Consultation Response from KC, Highways Development Management (HDM)**2025/93229 Land off, Westgate, Cleckheaton, BD19 5DR****Discharge of details reserved by conditions 15 (drainage), 33 (waste), 37 (cycle parking), 41 (LEAP) on previous permission 2021/93567 for demolition of existing commercial buildings and erection of 180 dwellings with associated works****Date Responded: 23/03/26****Responding Officer: A Darwin****Responding Ref: HDC 9-3SW/6****RECOMMENDATION: Amendments required**

HDM have been consulted regarding the discharge of condition application 2025/93229, relating to Conditions 37 (cycle parking) of previous permission 2021/93567, which states:

SD8.EW.08

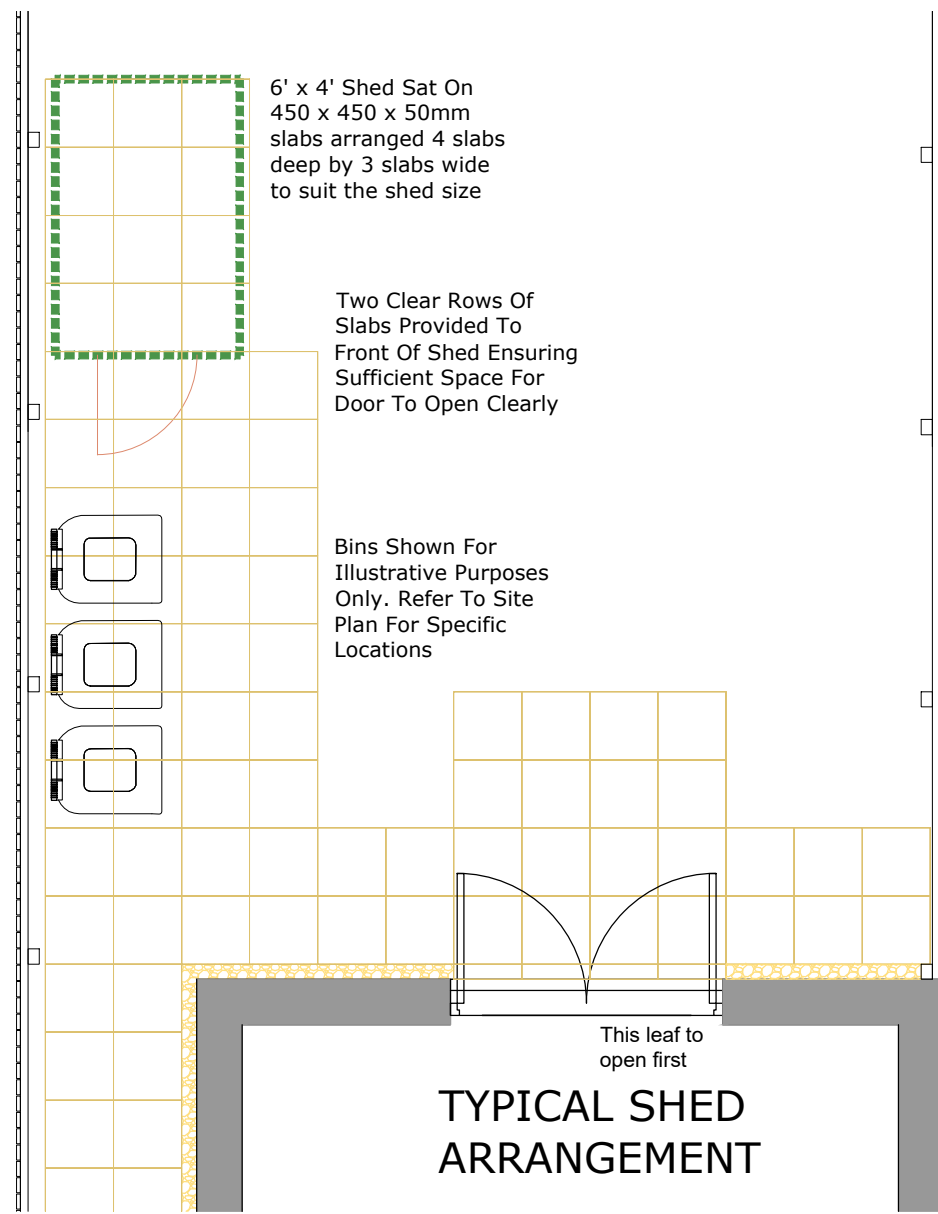
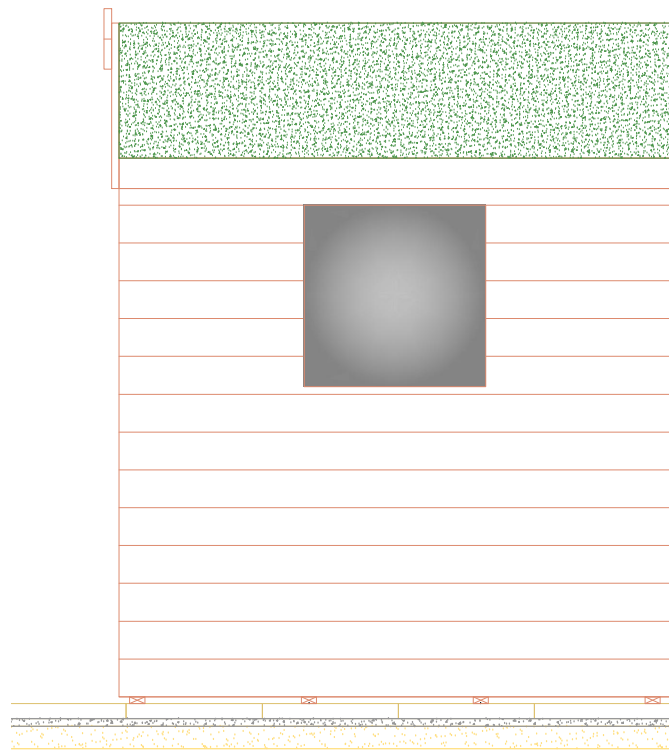
However, the drawings show a shed dimension of 6'x4', which is insufficient to accommodate larger bikes. In accordance with LTN 1/20 (Table 11-2), a minimum length of 2m (internal dimension) is required for floor standing cycle storage. Therefore, a larger shed is required.

It is also recommended that the sheds are sufficiently sized to accommodate other essential items (e.g. garden tools/equipment) and include wider doors (only 660mm wide doors are currently proposed) that will allow easier access to the cycle storage, and enable a wider range of cycle equipment to be stored (e.g. cycle trailer that would require door width of circa 900 - 1000mm).

In light of the above, it is recommended that Condition 37 is not discharged until revised details are provided of a suitable shed type.
